Our Case Number: ACP-323606-25

Re: Proposed construction of 67 no. housing units
on a site at Tyrells Land, situated along Stradbally Road, Portlaoise, Co Laois

Our Ref: C25-003 L2 - An Coimisiún Pleanála
Reply to: 2 John St., Kilkenny, mail@boda.ie
Date: 9th February 2026

Re: Tyrrell's Land, Stradbally Road, Portlaoise, Co. Laois Section 177AE
Re: Case reference: ACP-323606-25
Client: Christopher Fingleton and Mary Tyrrell, Portrane House, Stradbally Road, Portlaoise.

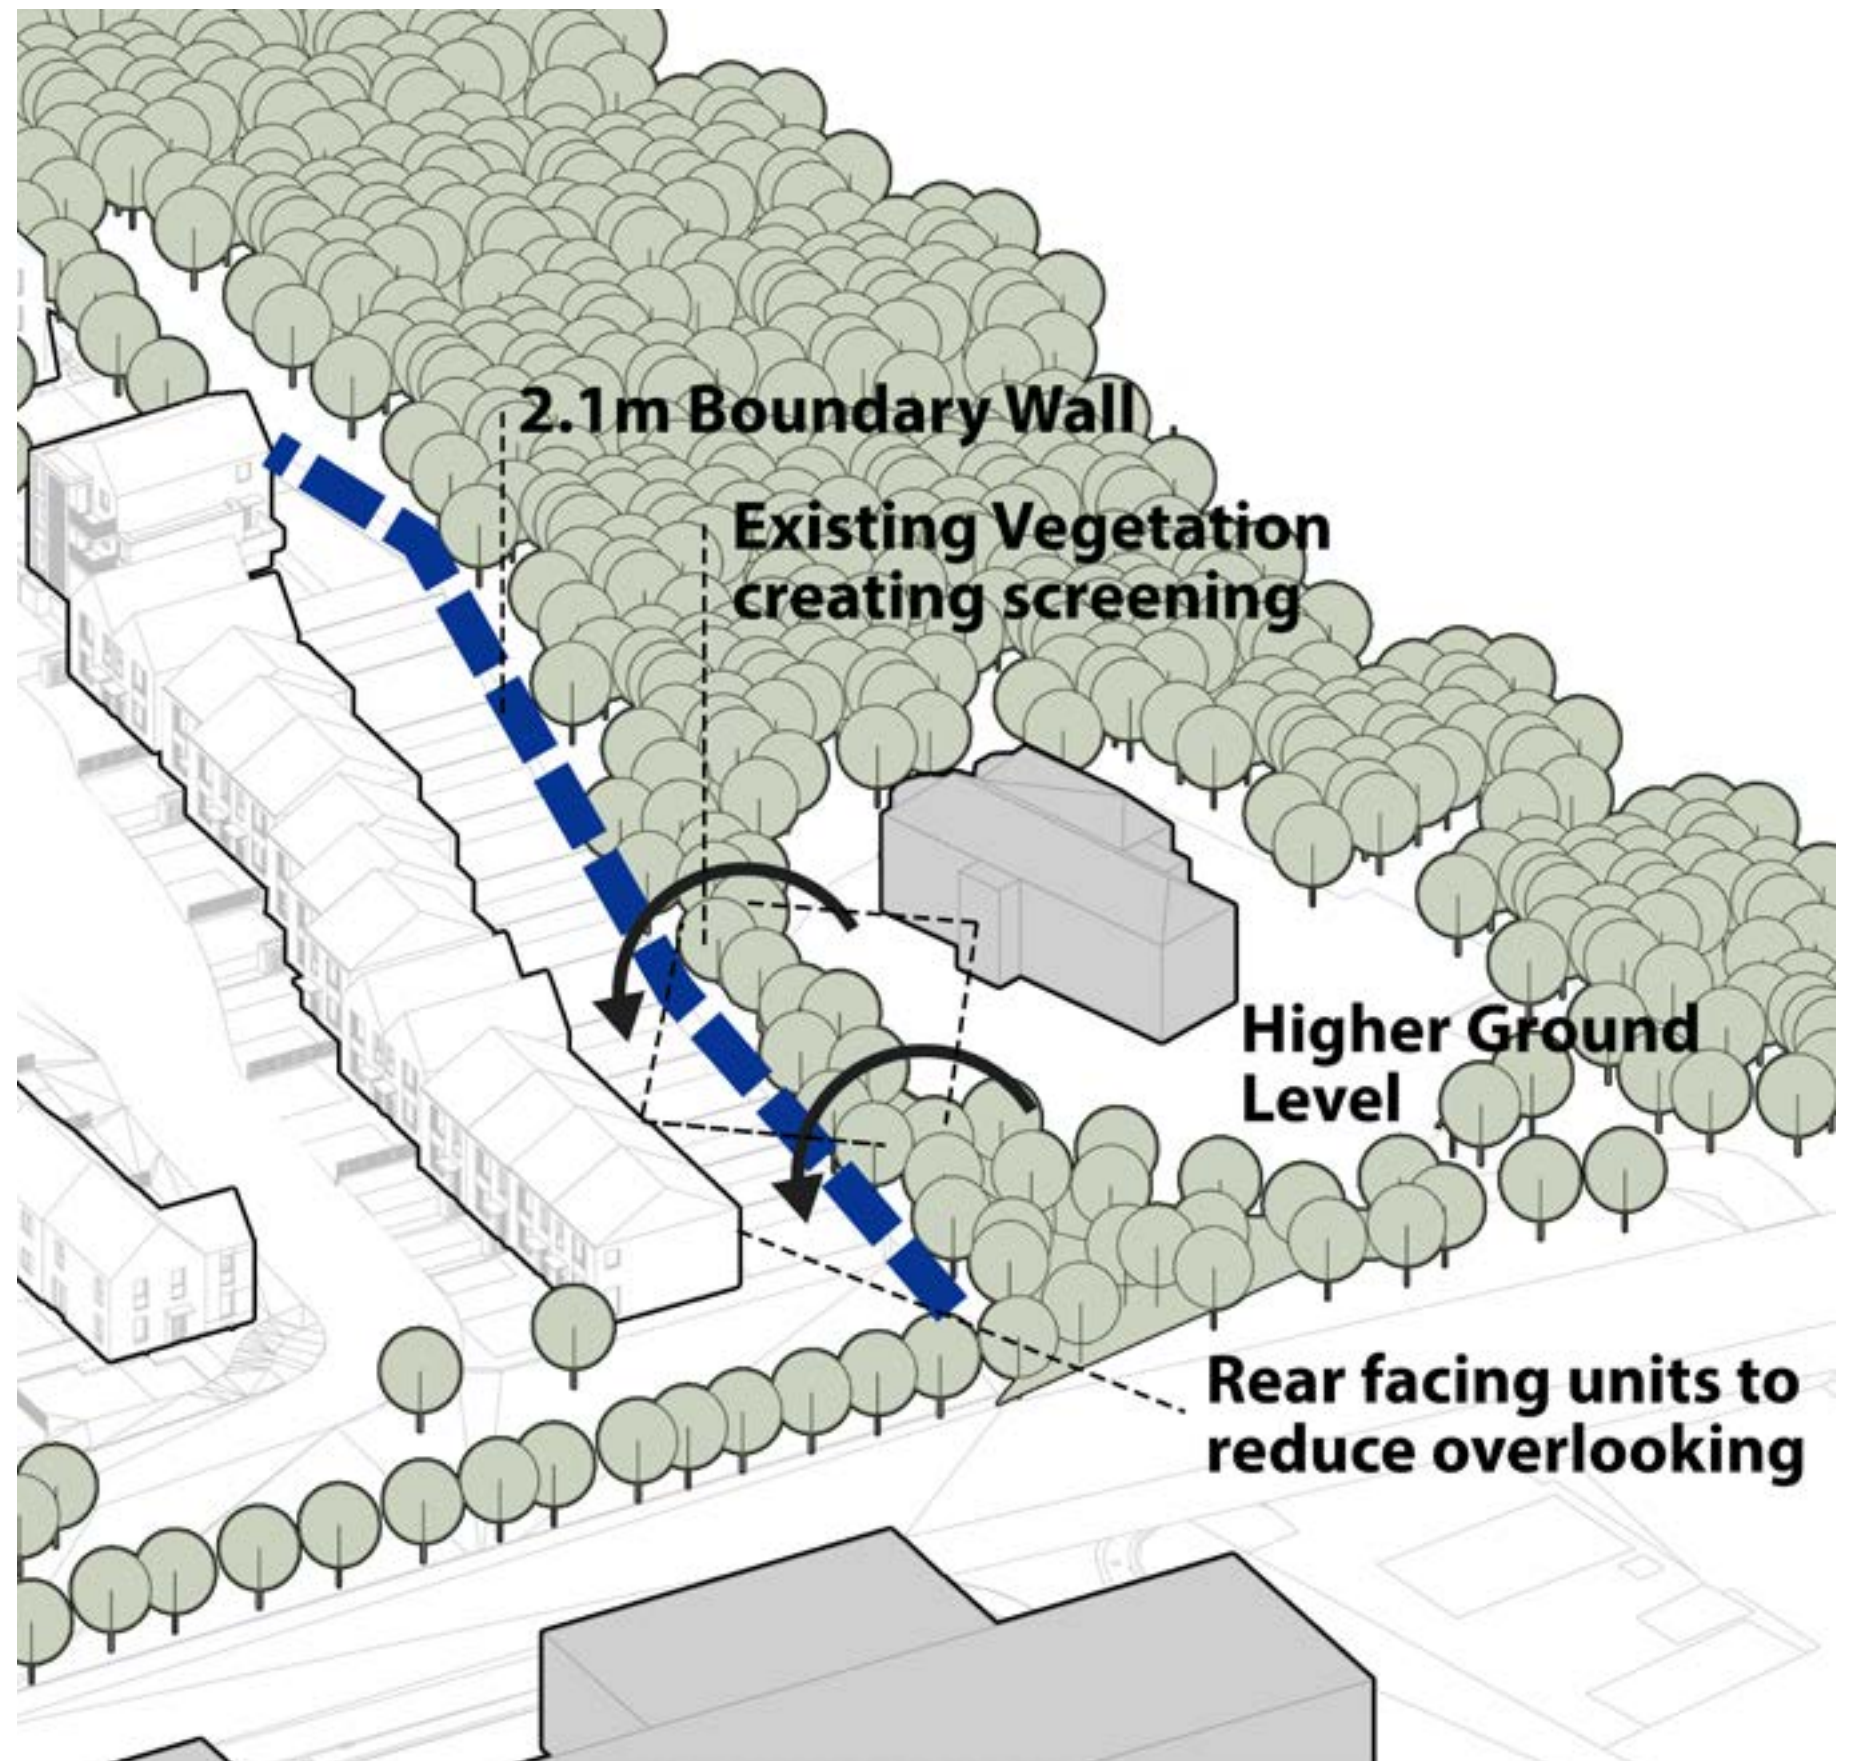
Item 7 We also note the Council's comments regarding the boundary wall treatment.

“ A 2m block wall with appropriate capped finish, landscape buffer, and native tree planting (already proposed) achieves: No adverse impact on heritage significance.”

Please see Photo 1 from the Design Statement prepared by van Dijk Architects of the wall on the front boundary. This ties into the overall concept of the scheme. There is a requirement to respect the setting of the protected structure and where the vista is provided with an open space, the most appropriate wall finish would be stone masonry. This would be similar to the current setting walls as noted in the design statement.
